Application for a non-material amendment following a grant of planning permission.

Number	120
Suffix	
Property name	
Address line 1	Laund Road
Address line 2	Salendine Nook
Address line 3	
Town/city	Huddersfield
Postcode	HD3 3TY

Demolition of Existing Dwelling and erection of 7 No. Dwellings	
Reference number:	2019/90486
Date of decision	12/06/2020

Raise Plot 2 by 350mm

PLOT 2 PLANS

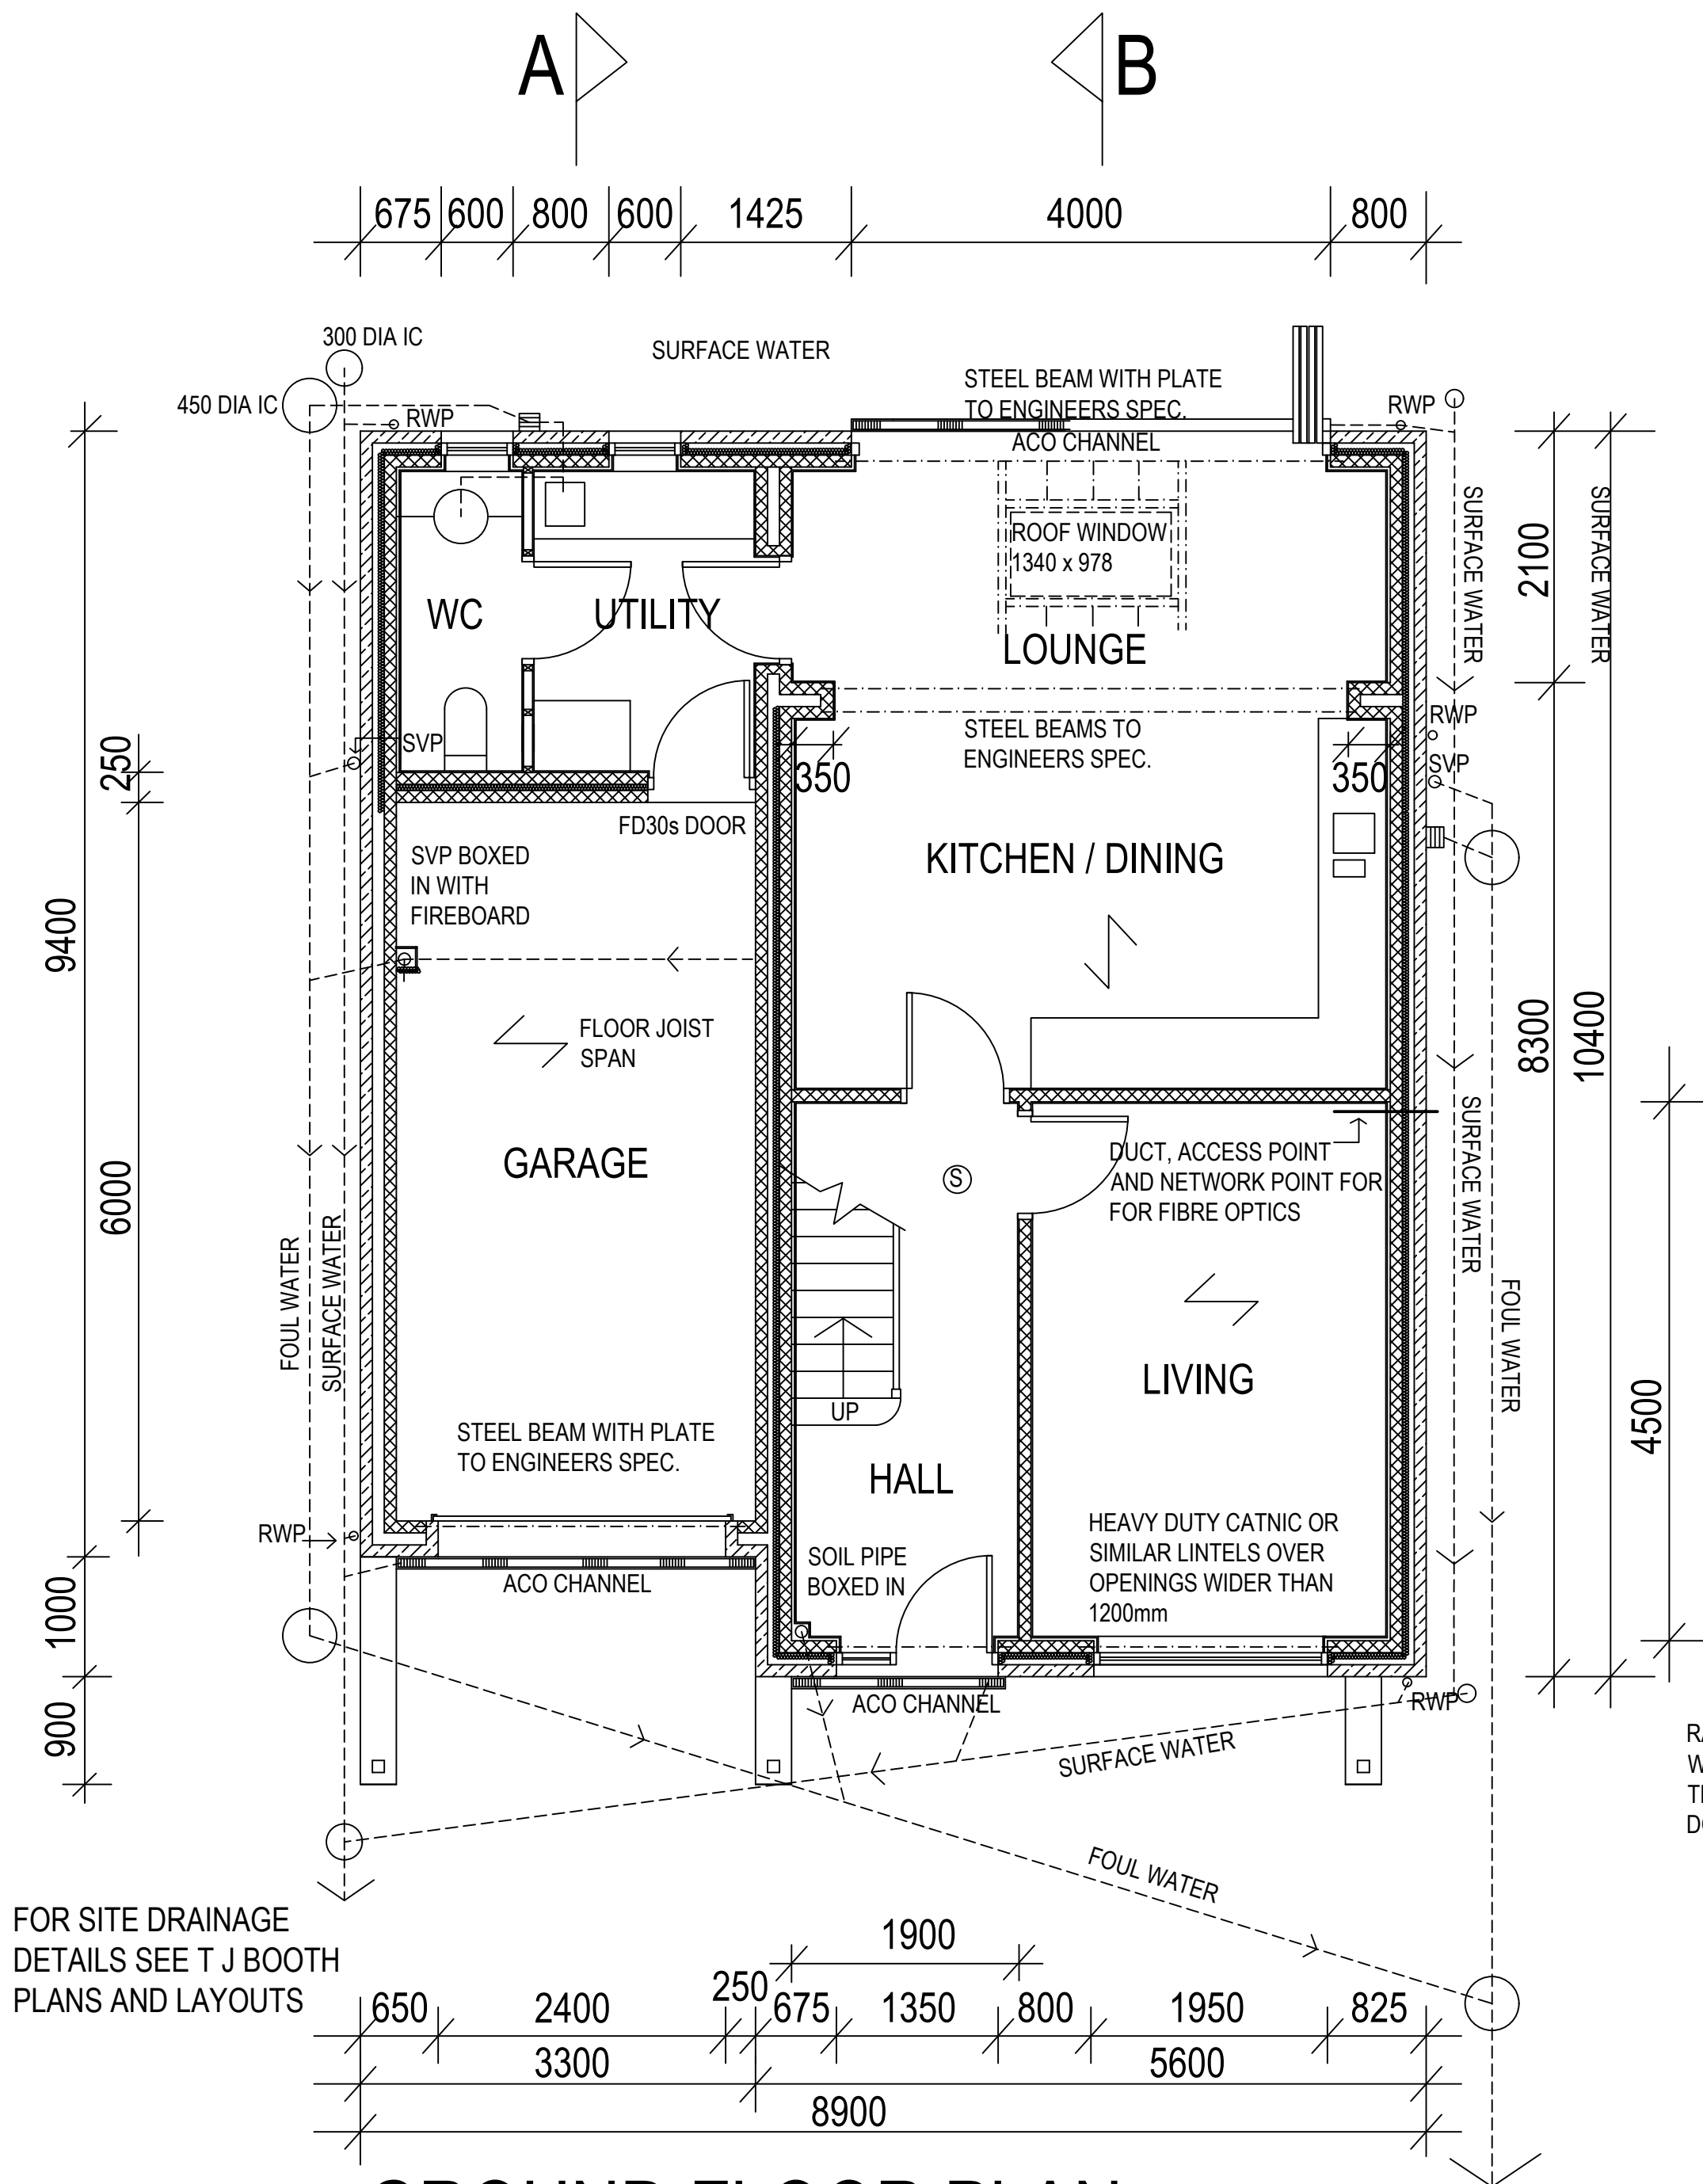
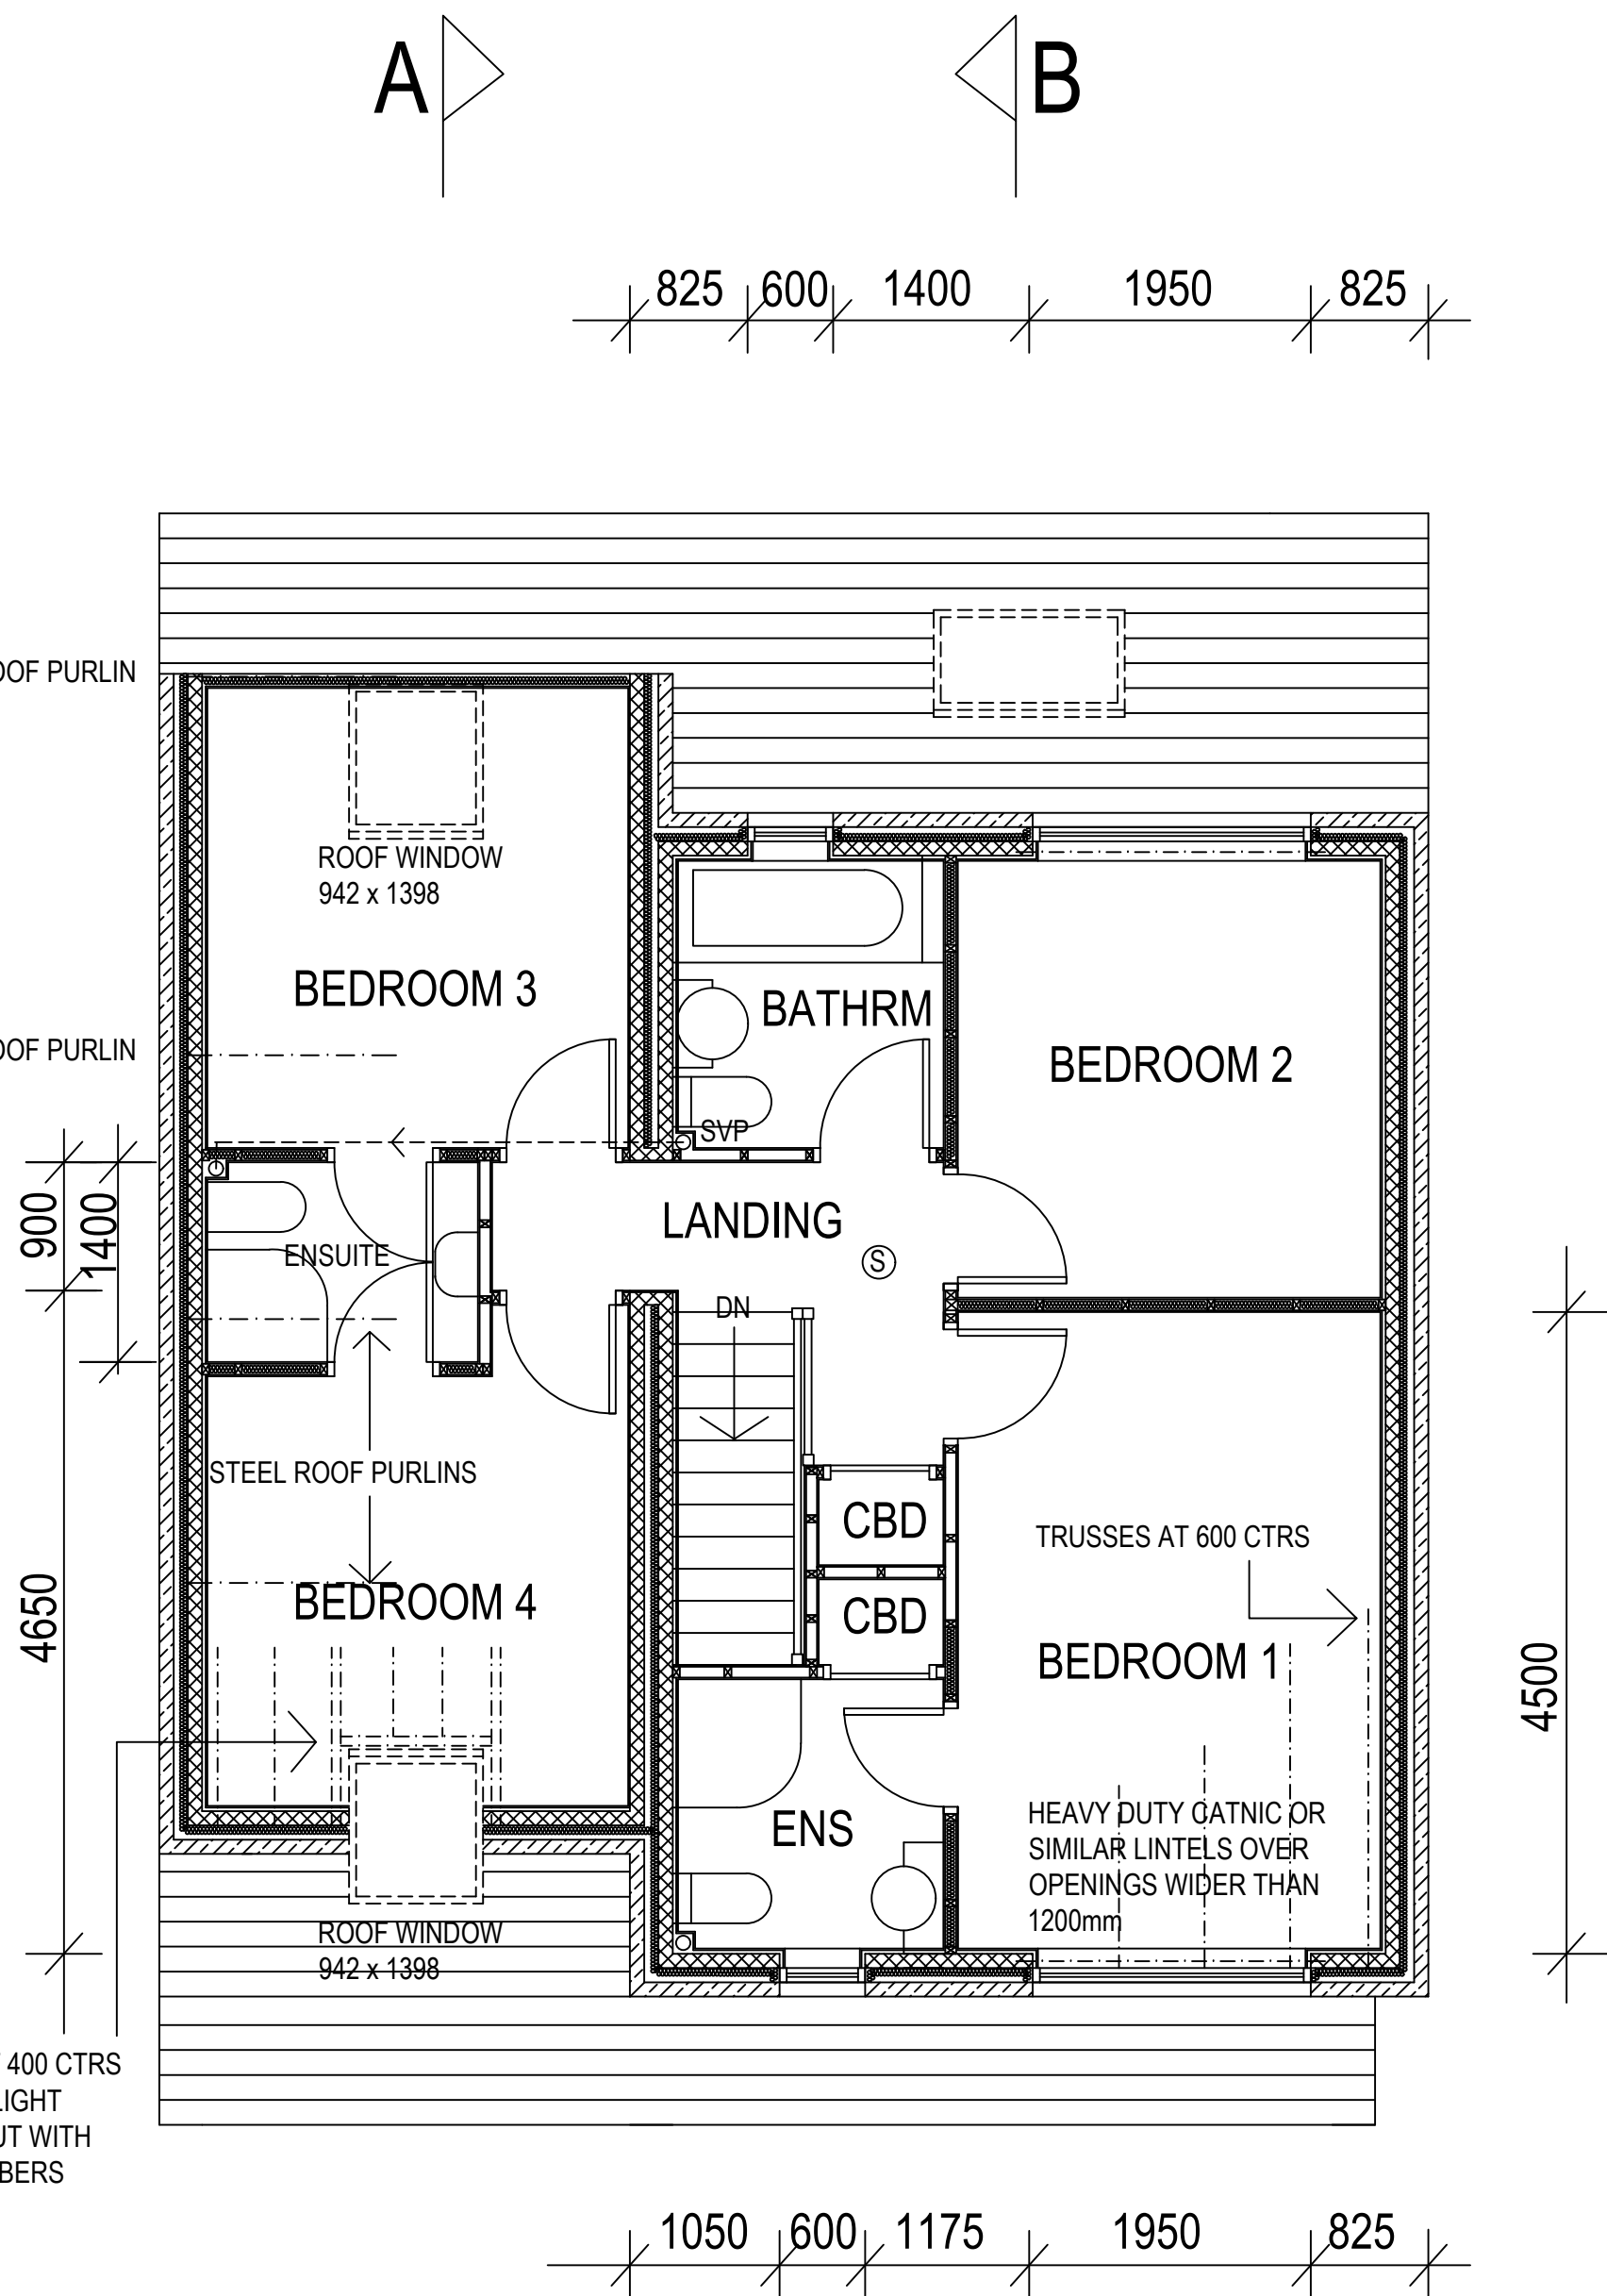
Due to the floor construction changing, from solid to suspended beam and block, due to incorporation of gas membrane
